# Rezoning Transportation Analysis

Petition Number: 2020-075

General Location Identifier: Tax ID 02972112

Date	Description
07-23-2020	First Review

CONCEPTUAL SITE PLAN
REZONING PETITION #2020-XXX
RIDGE ROAD HUNTER TOWNHOMES
MATTAMY HOMES
CITY OF CHARLOTTE

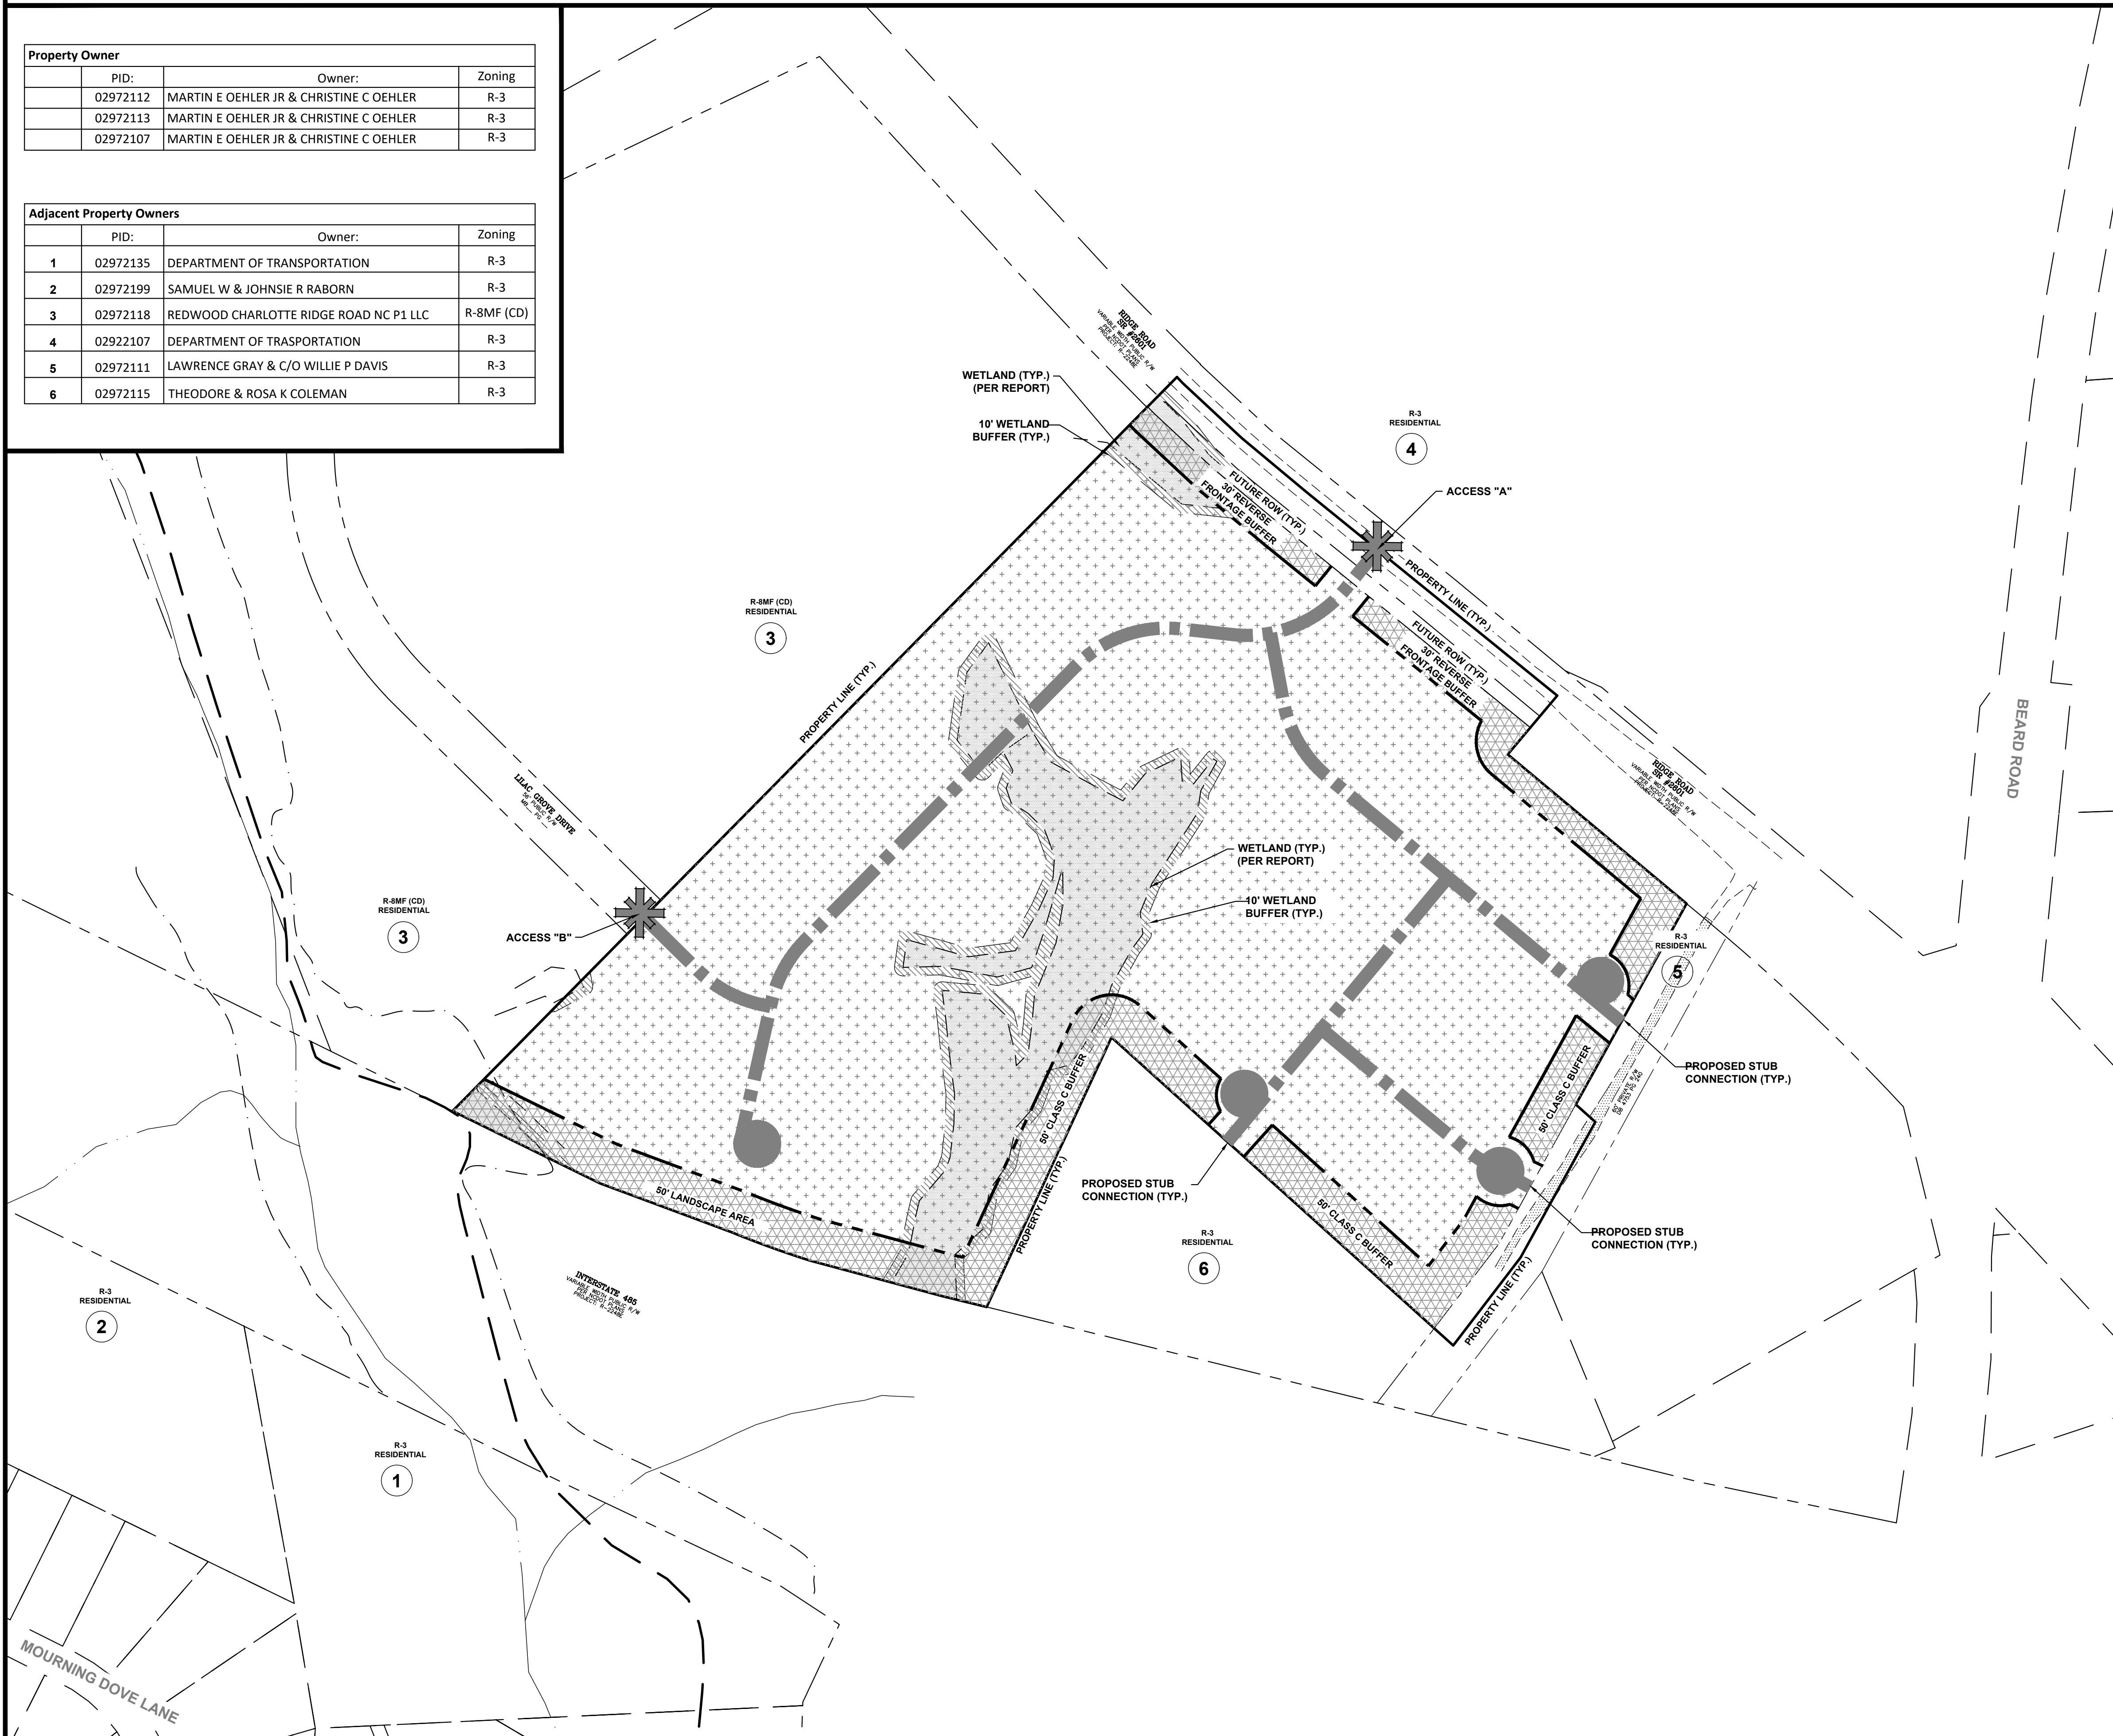
**Ridge Road:** The future location of curb and gutter should be reflected to match the Prosperity Hucks Area Plan cross section, as shown below. Pavement widening should occur asymmetrically to the south of the proposed petitioner's site, since the parcel across Ridge Road to the north is a mitigation site for I-485 construction and is protected by a conversation easement. Please refer to **SDRMFR-2019-00041 - Redwood Ridge Road** to tie-in the proposed streetscape into the approved Redwood Ridge Road subdivision plans.

The site plan should show the curb and gutter labeled and dimensioned from the centerline for each road.

- In accordance with the CRTPO Comprehensive Transportation Plan (CTP), the petitioner should revise the site plan and conditional note(s) to commit to dedicate a minimum of 50 feet of right-of-way from the Ridge Road centerline for a major thoroughfare. The site plan should label and dimension the right-of-way from the road centerline. CDOT requests right of way set at a minimum of 2' behind back of sidewalk.

- The petitioner should revise the site plan and conditional note(s) to commit to construct a 10-foot sidewalk in accordance with the Ridge Road cross section, as included within the Prosperity Hucks Area Plan. The site plan should label and dimension both items from the back of curb and gutter and road centerline.

- The petitioner should revise the site plan and conditional note(s) to commit to provide a 3-lane driveway section at proposed Access A, to provide one thru lane (ingress) and a right and left-turn lane (egress).

- The petitioner should revise the site plan and conditional note(s) to provide a left-turn lane, with the appropriate storage and bay taper, on Ridge Road entering the proposed Access A into the site.
